Please ask for: Sian Eggington
Email: sian.eggington@terraquest.co.uk
Telephone: 0121 2341390
Our Ref: LU/82/21/HH
Your Ref:
Date: 19th March 2021

Application for Planning Permission for Works or Extension to a Dwelling

Development: Erect a new garage as a continuation of the north eastern projection.
Convert existing garage to a home office, utility and shower room.

Location: 101 Griffin Crescent Littlehampton BN17 7LH

EXISTING ELEVATIONS

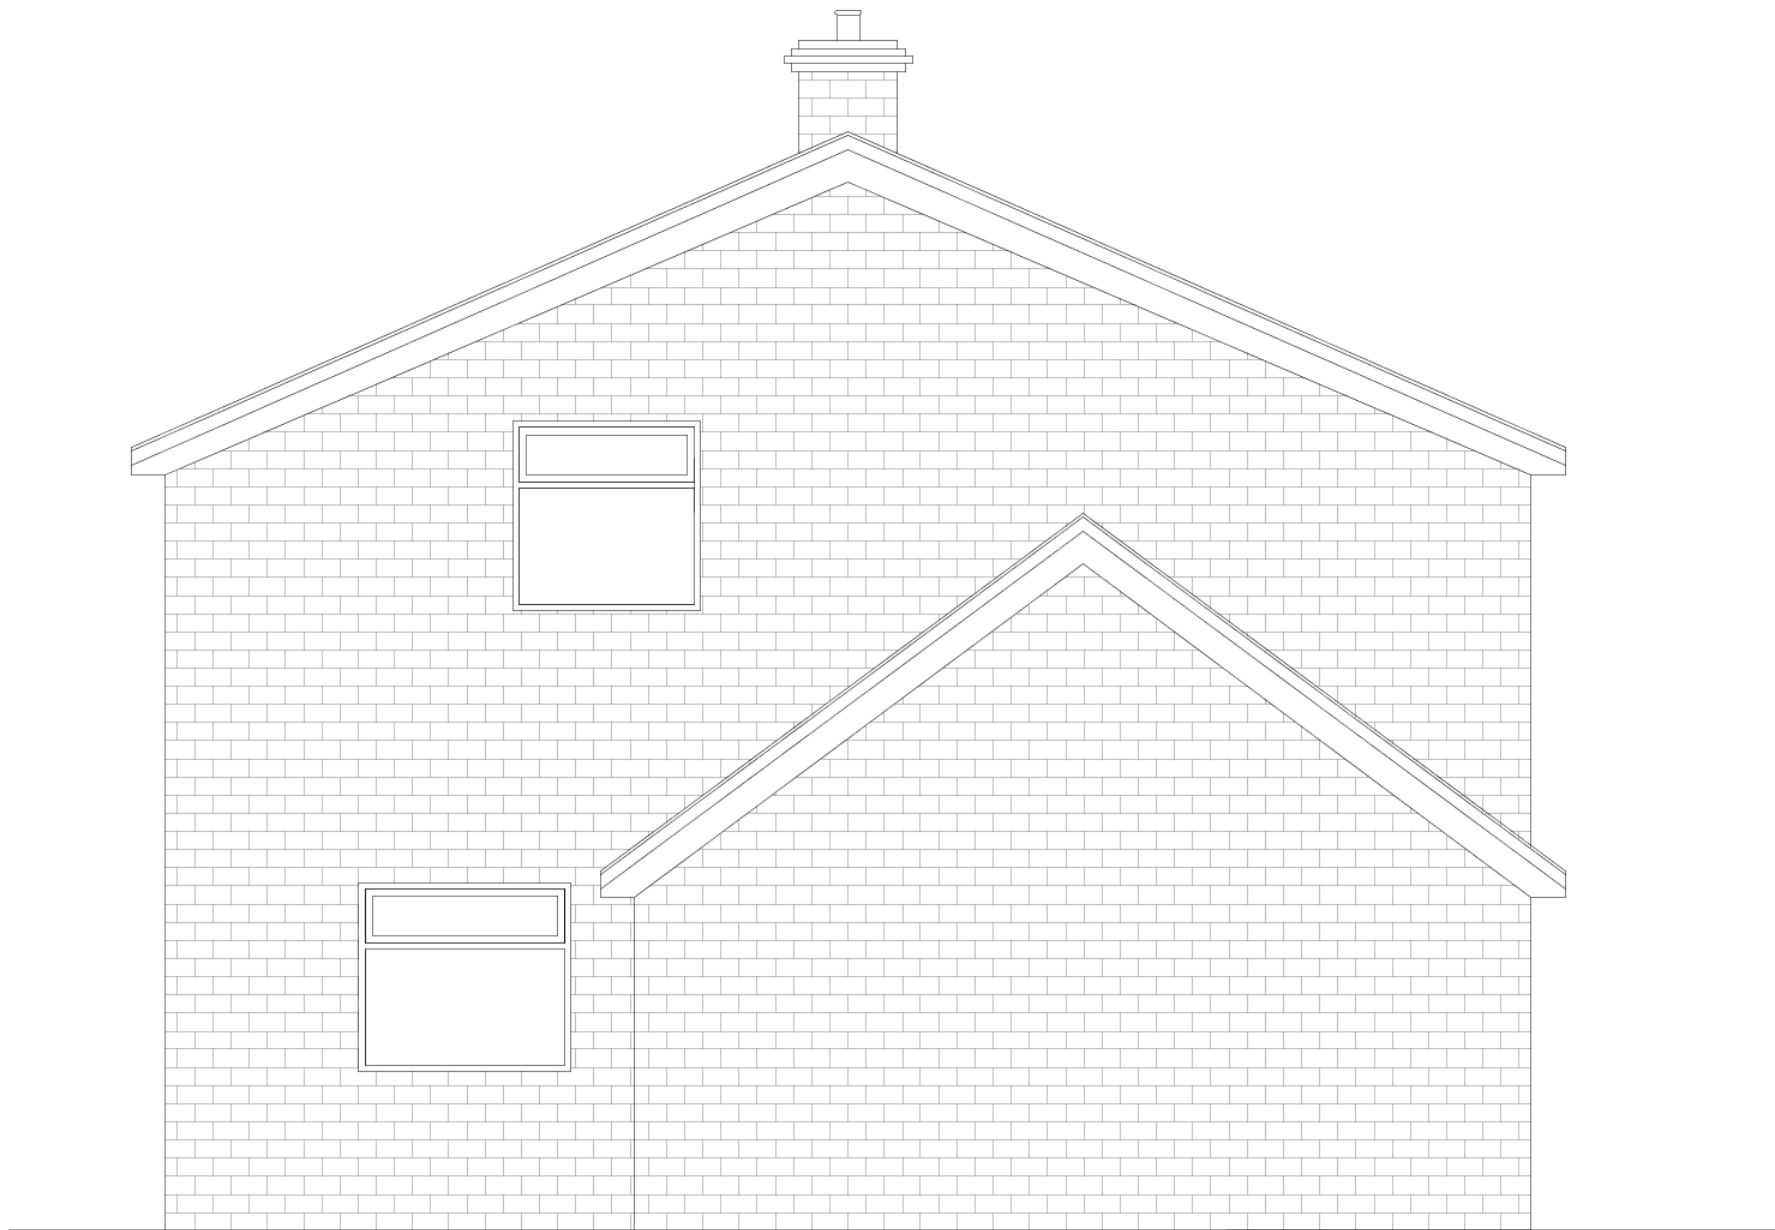
Elevations

Please submit a copy of clearly labelled existing and proposed elevations at a scale of 1:50 or 1:100. Further details can be found in the Validation Requirements List.

Block PLAN

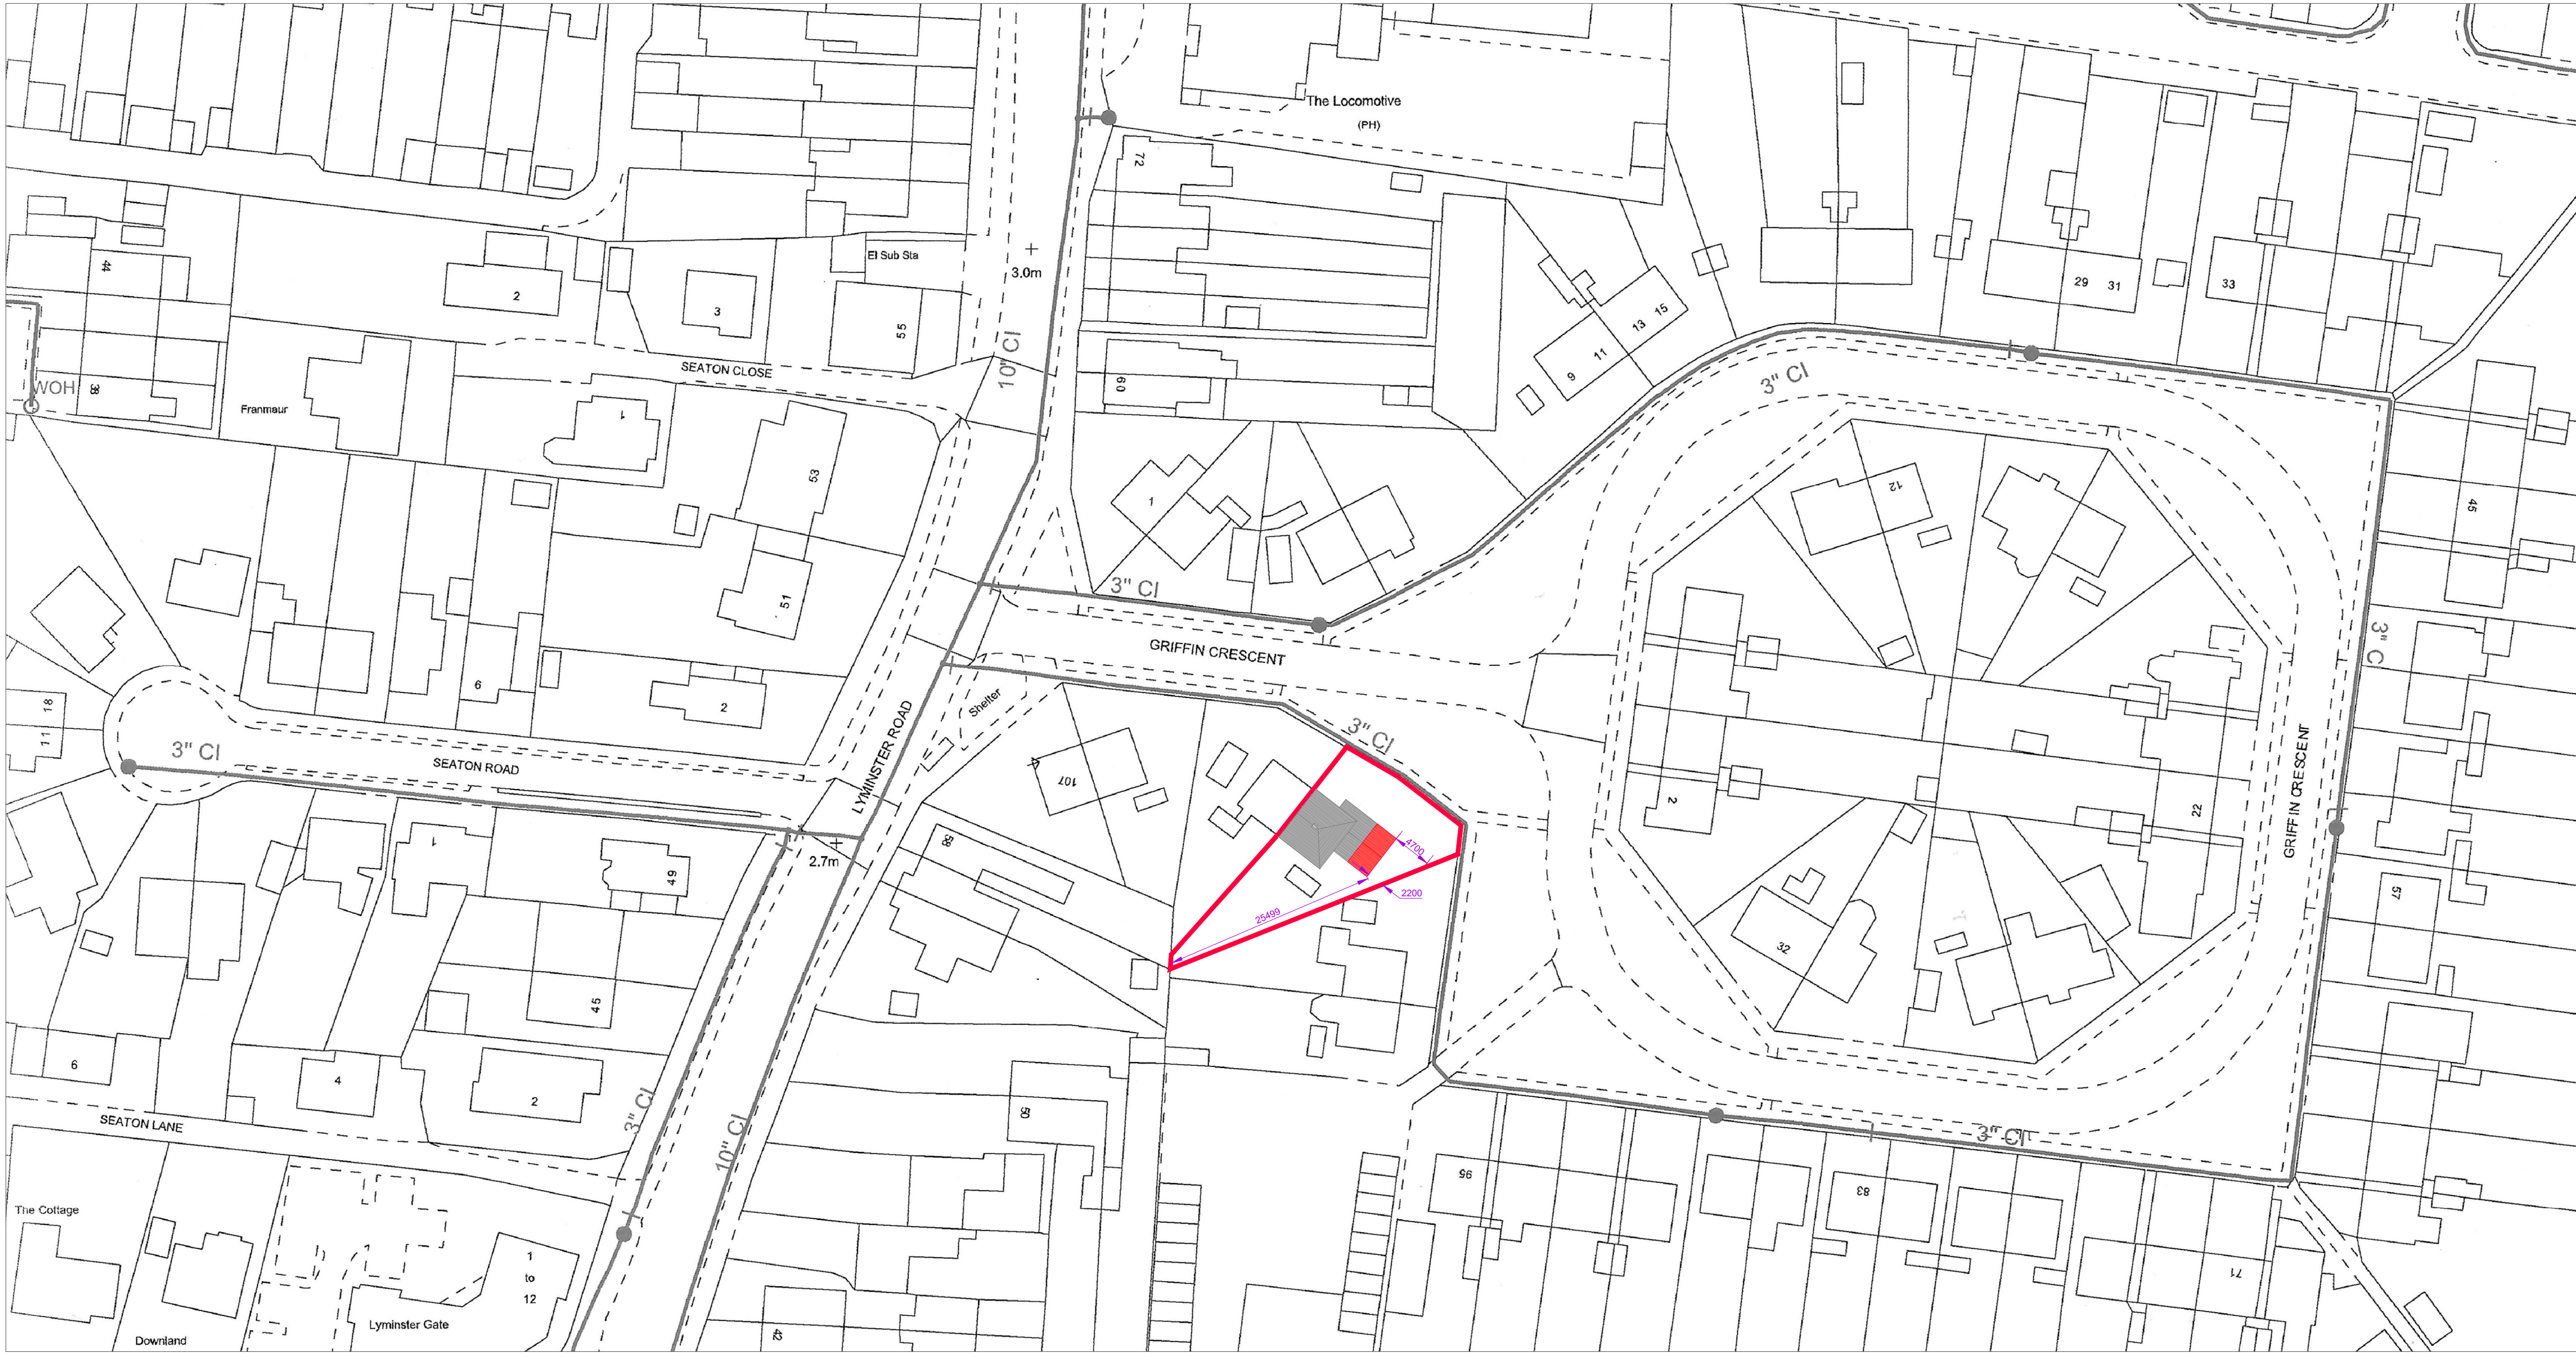
Block Plan

You are required to have dimensions from the proposed extension(s) to all site boundaries. Please amend.
